Bayside Council

Re: Bayside Council Submission on SSD-0154 – Qantas Flight Training Centre

**DRAFT BAYSIDE COUNCIL SUBMISSION
STATE SIGNIFICANT DEVELOPMENT
QANTAS FLIGHT TRAINING CENTRE (SSD-10154)**

- A2
- KING ST. TREES AMENDED
 - LANDSCAPE AREAS/TREES ADDED
 - CAR SPACE DELETED
 - RAINWATER TANK ADDED

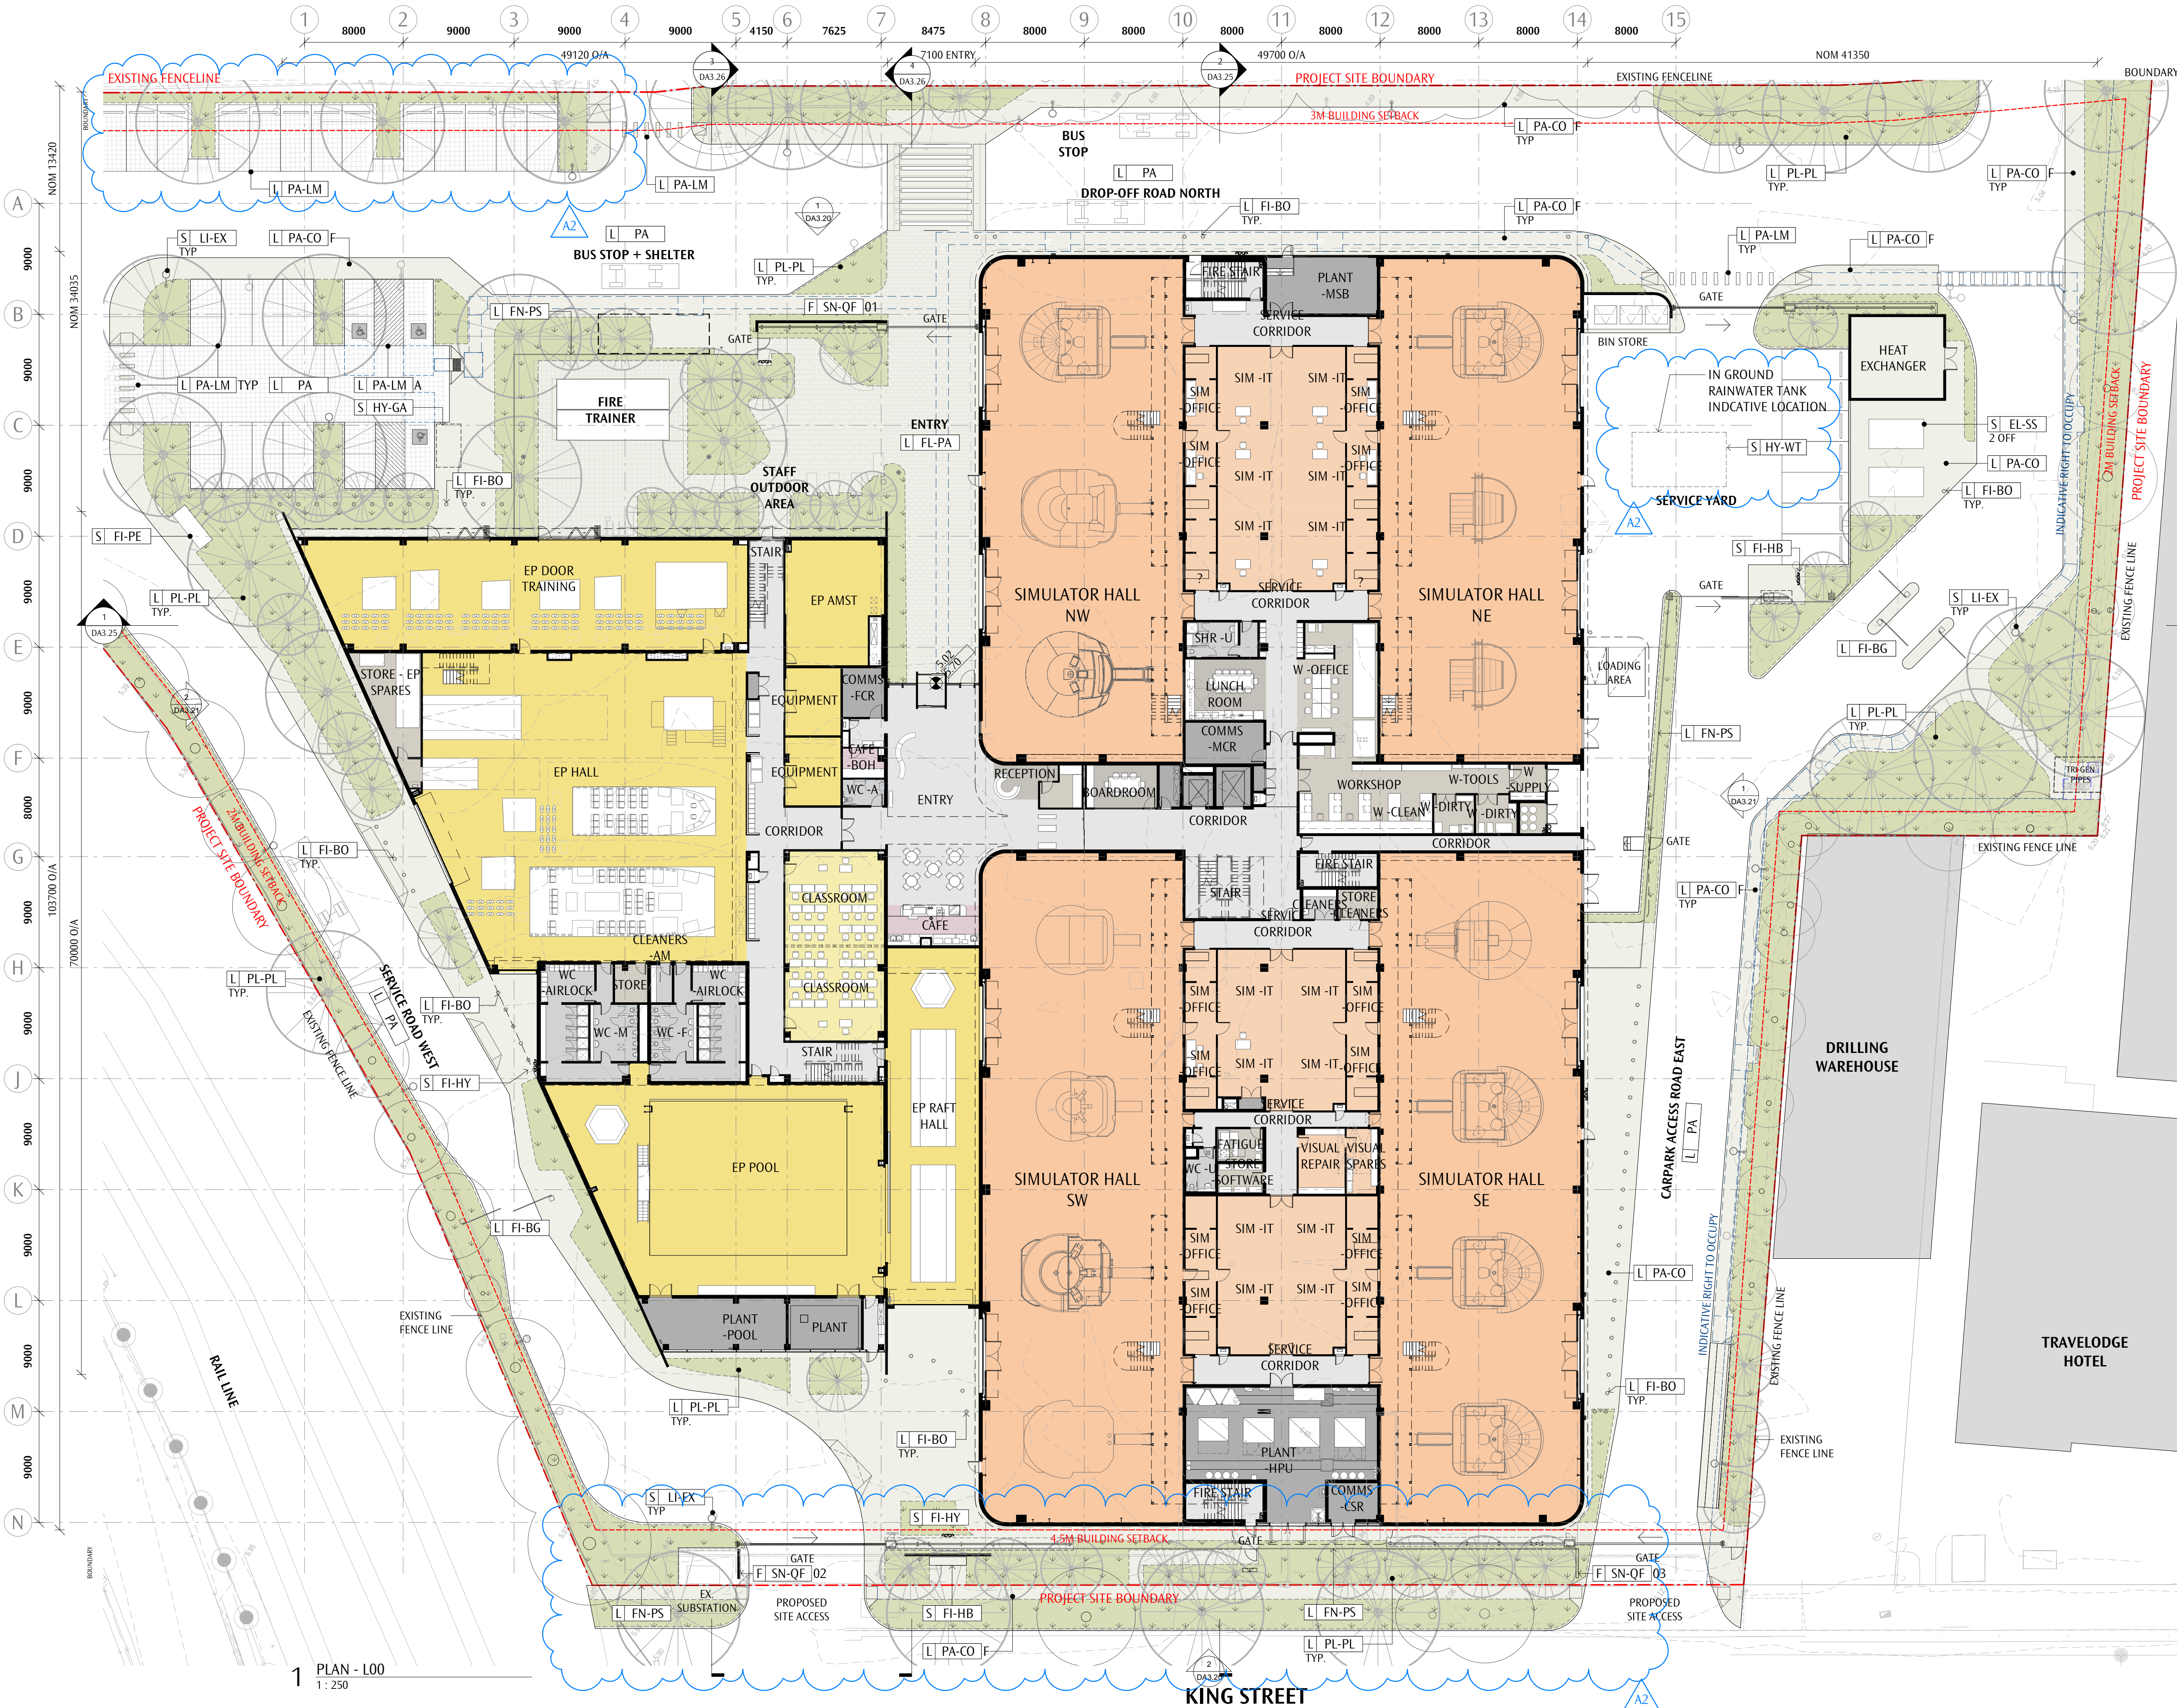
- The landscaped area required is 10% of the site. Landscape setbacks can be included in the calculation except for the front setback area as defined in the Botany Bay DCP 2013 Part 6.3.5 Setbacks, control 9. Therefore the proposal shall provide 5,417m² without including the 3 metre landscape setback along King Street. The landscape area provided in the proposal reaches approx. 3,458m², representing 6.3% of the site.

- Considering the removal of existing vegetation including an area of an endangered ecological community (Swamp Oak floodplain swamp forest), and the minimal deep soil area provided the landscape proposal shall use locally indigenous plant species, and trees shall be planted in advanced form, between 200 to 400 litres container sizes.

- The proposed at grade carpark provides some opportunity for canopy cover to the hard surface areas. To comply with Part 3L.6 Landscaping in Car parks, Control 1 of Botany Bay DCP 2013, one (1) tree should be provided for every 5 car spaces so that at least a 50% canopy coverage of the car park at maturity is provided. Car parks will be generously landscaped.

- King Street nature strip shall be planted with street trees as required, pot size shall be minimum 200 litres. Trees shall be planted in a tree pit with a slotted pipe watering system (Rootrain Urban, or equivalent). Bicycle racks and seating shall be included in proposal as necessary. All landscape works within public domain shall be as per Bayside Council specifications.
